Application for Removal or Variation of a Condition following Grant of Planning Permission or Listed Building Consent

Erection of a two storey rear extension and a single storey rear and side extension. at 58 Woodfield Drive, Winchester, SO22 5PU

21/02461/HOU

Condition 2

JOB NO.	DRAWING NO.	REV
1006	400	T3

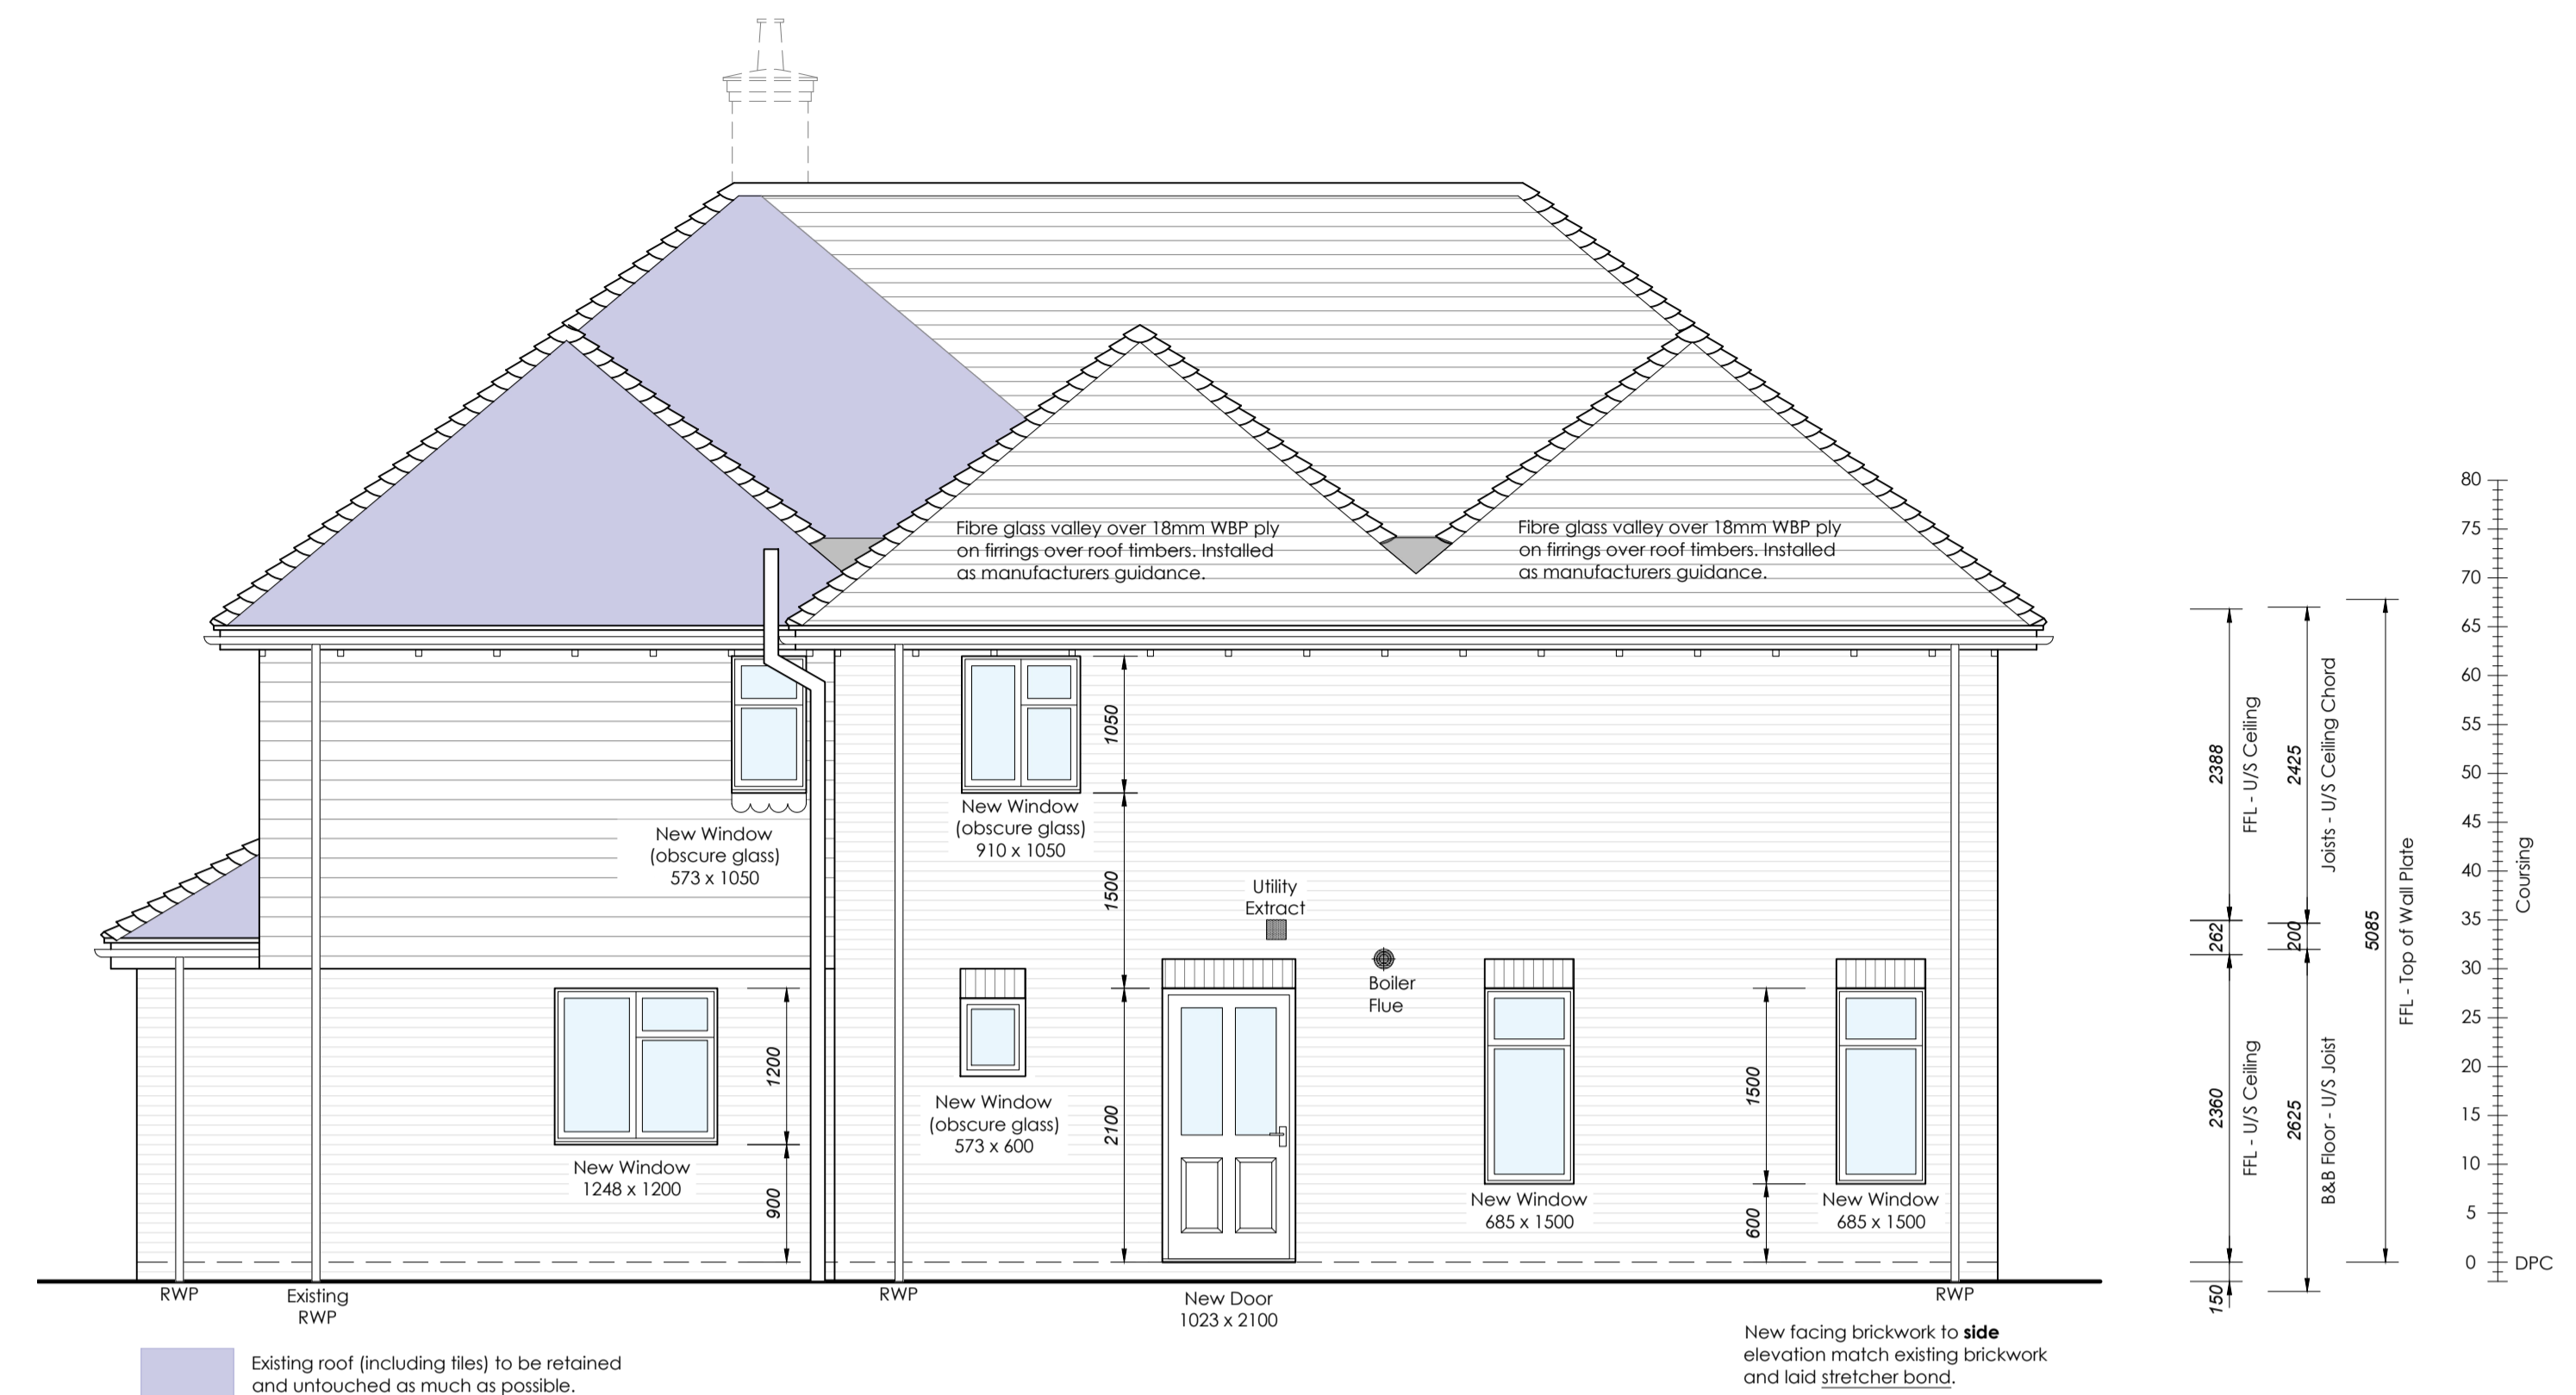
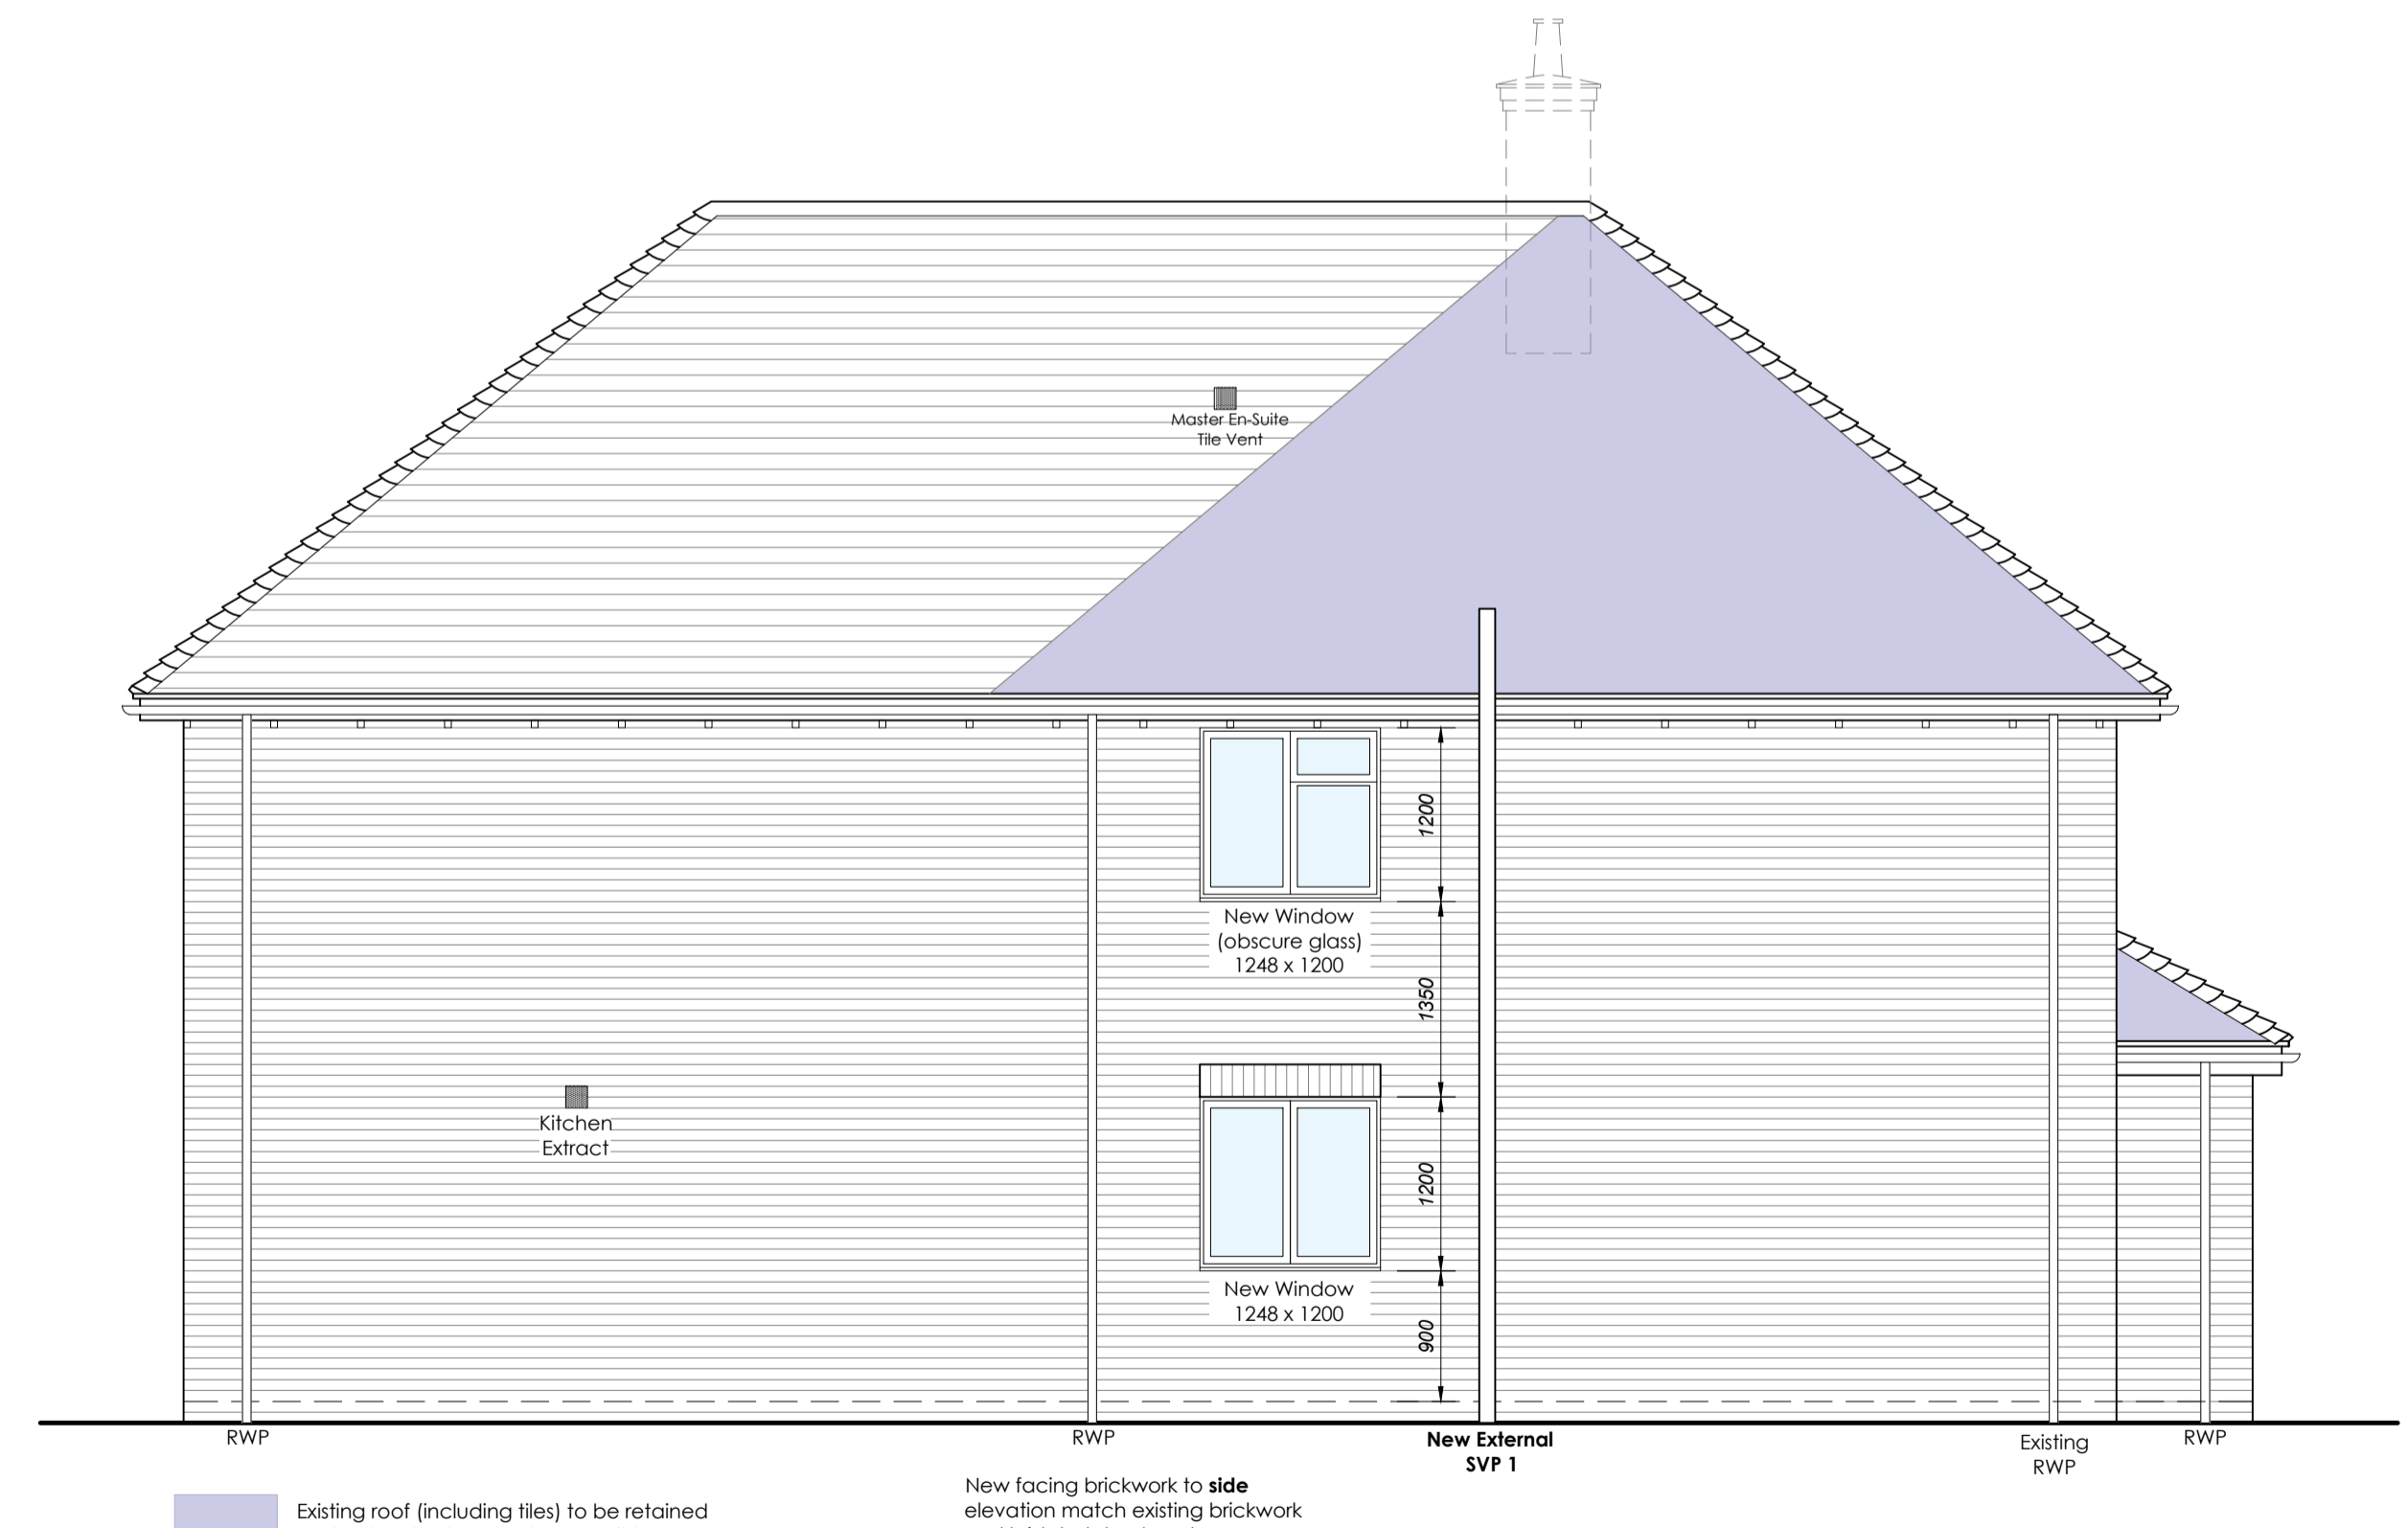
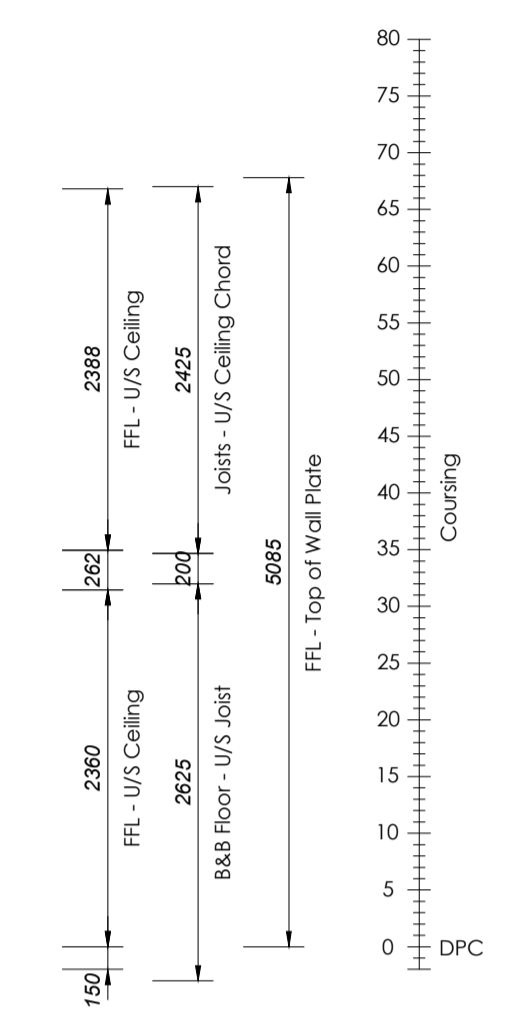
For financial reasons we have undertaken a value engineering exercise. The conclusion of this this exercise has been to reduce the footprint of the extension by removing the single storey side extension and also retaining as much of the existing roof as possible. The previous scheme removed the entire existing roof and replaced with new, however, a quicker and more constructible way has been established to tie the new extension area into the existing roof structure.

- 1006-100 T3 SUBSTRUCTURE AND ROOF PLANS
- 1006-200 T3 GROUND AND FIRST FLOOR PLANS
- 1006-400 T3 ELEVATIONS
